# CITY OF ALBUQUERQUE

**Re: McMahon Shopping Center  
McMahon/Unser NW  
Traffic Circulation Layout  
Architect's Stamp 07-20-2021 (A11-D017)**

Nilo Salgado-Fernandez, P.E.  
Senior Traffic Engineer, Planning Dept.  
Development Review Services

UNSER & MCMAHON  
ENLARGED SITE PLAN  
ALBUQUERQUE, NM  
PROJECT #2063

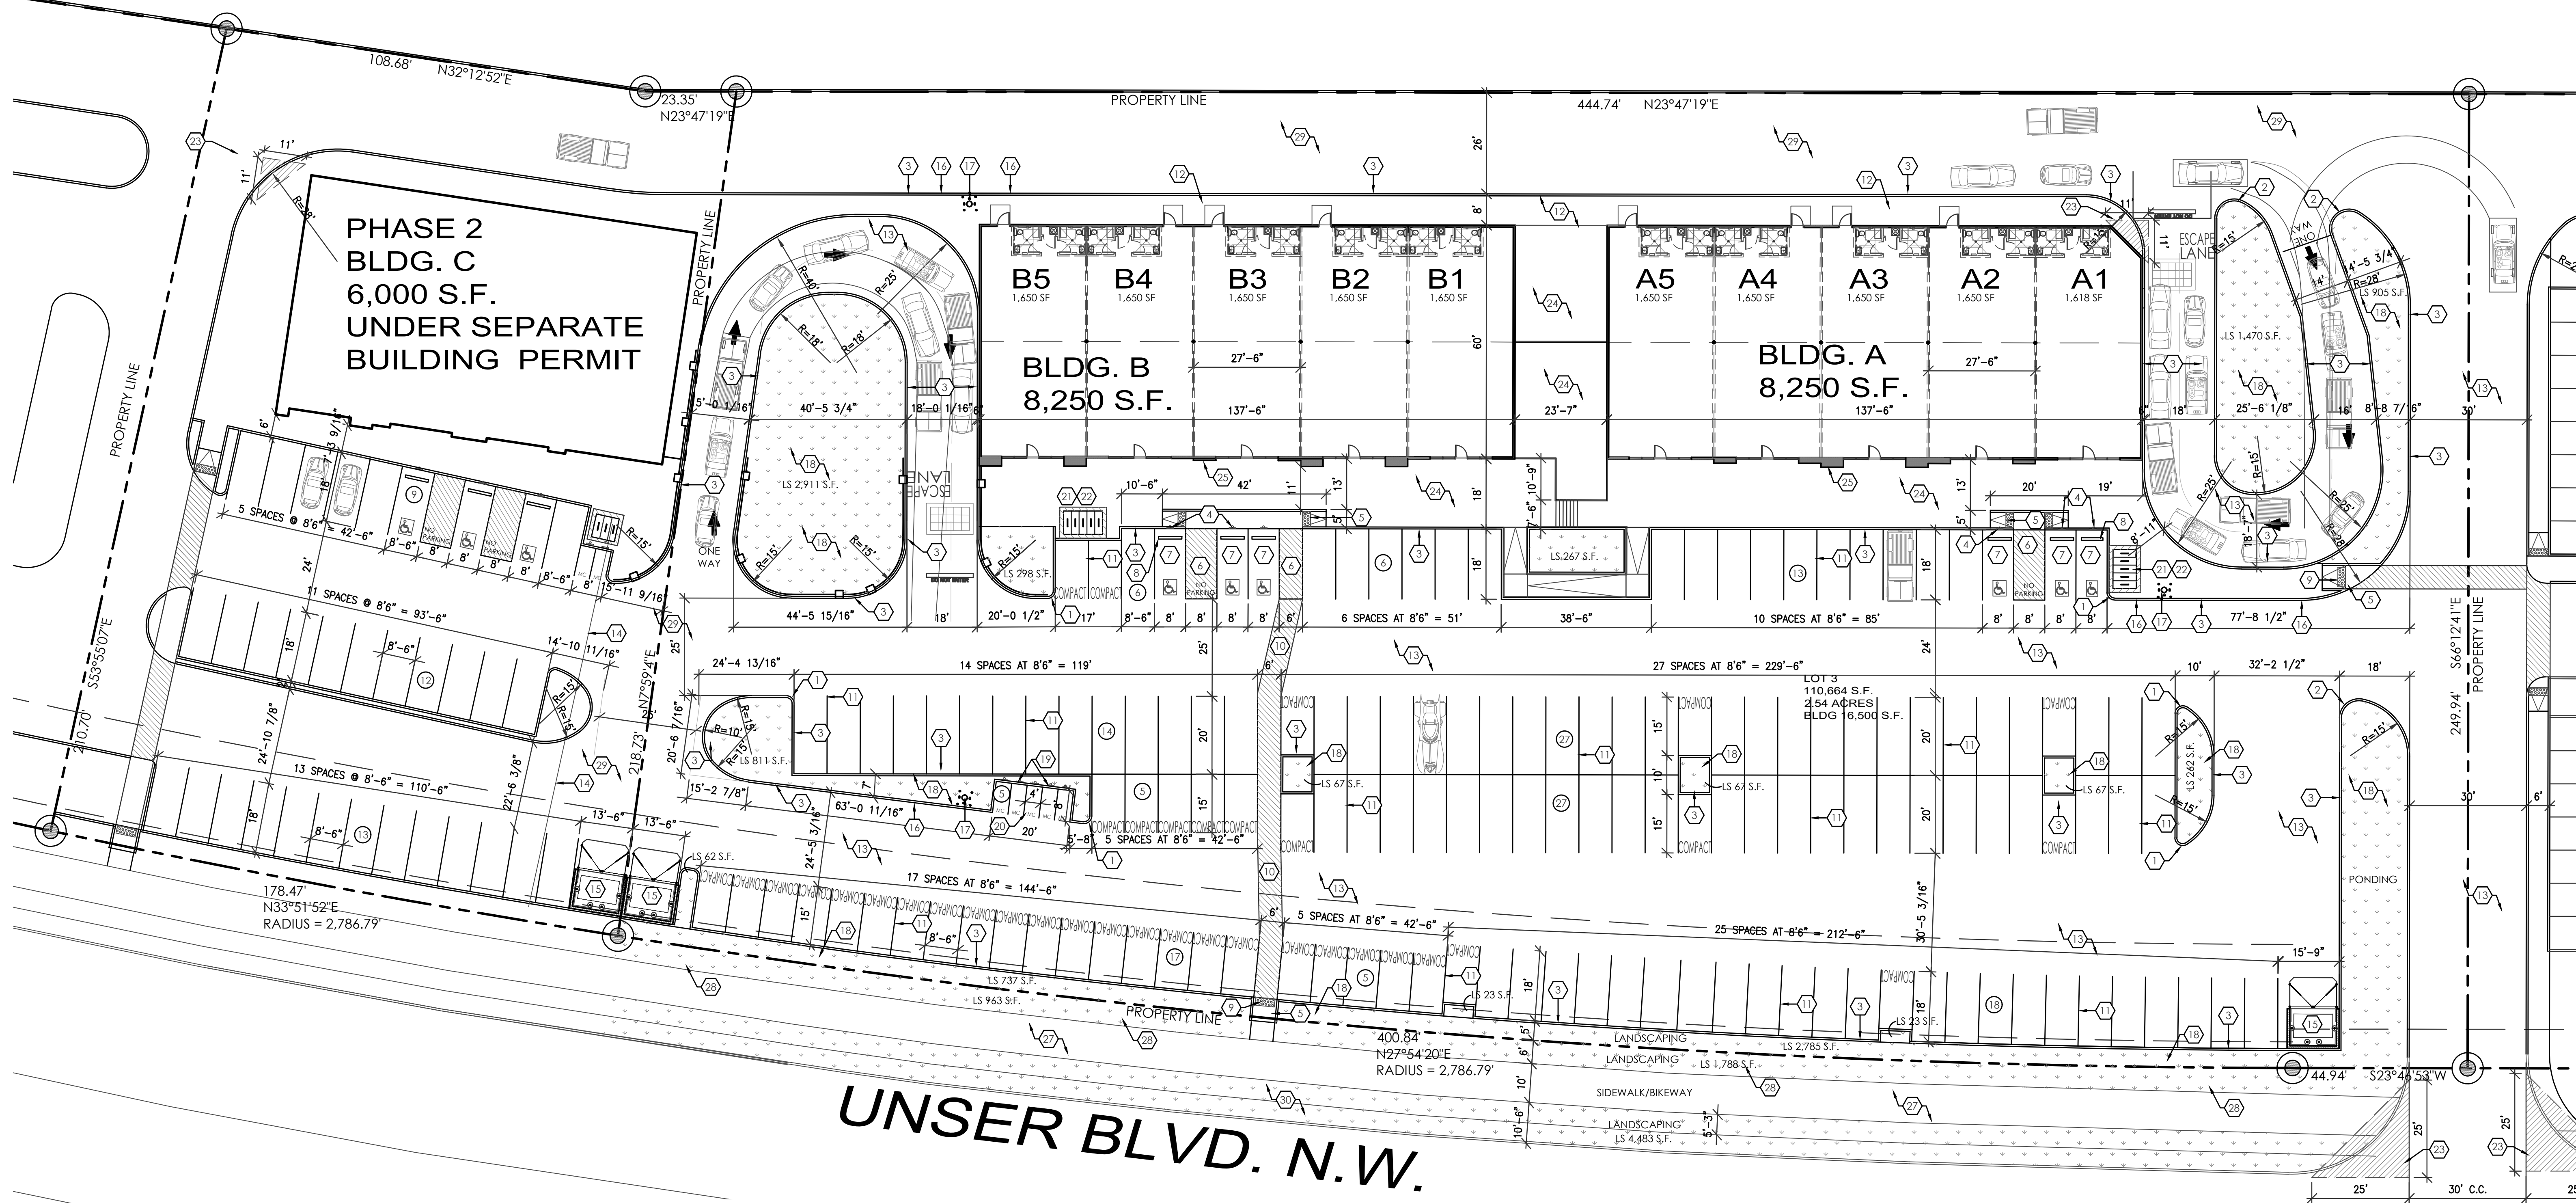
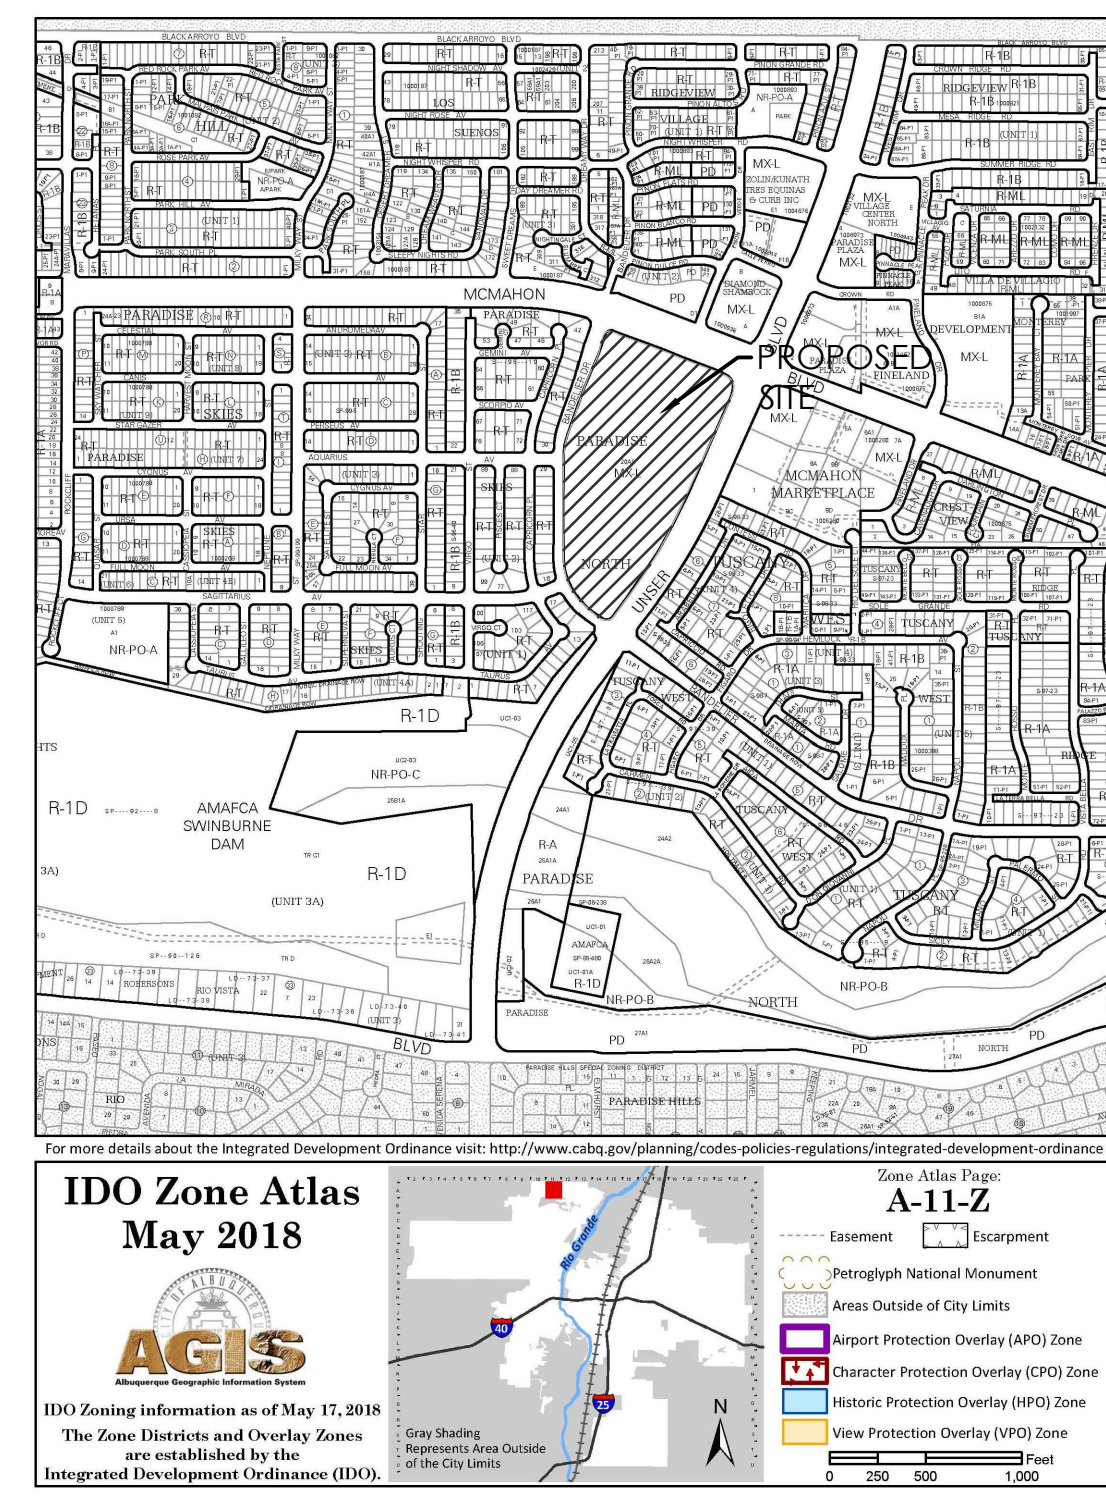
3. **Another access entrance/point is need to provide emergency accommodation for ingress/egress.**
4. How will you service the Main Circulation Road behind buildings A & B: **You show how a vehicle encroaches into the drive thru lanes which is a safety concern. Please address these concerns.**

10. Please list the width and length for all proposed parking spaces. **Some dimensions are not shown.**
11. The minimum parking stall dimensions are:

12. **ADA curb ramps must be updated to current standards and have truncated domes installed.**
13. Motorcycle parking spaces shall be designated by its own conspicuously posted upright sign, either free-standing or wall mounted per the zoning code. Label pavement MC.

19. Per the IDO, **a 6 ft. wide ADA accessible pedestrian pathway is required from the public sidewalk to the building entrances.** Please clearly show this pathway and provide details.

21. **ADA 6ft wide Pedestrian continuity needs to be provided between buildings A & B**
22. The proposed ADA parking stall:
  - Ramp are only 5 ft width. 6ft is the requirement.

- The back of ramps are a safety concern (tripping hazard) for pedestrians.
23. **Unser pathway: Provide widths of existing pathway.**
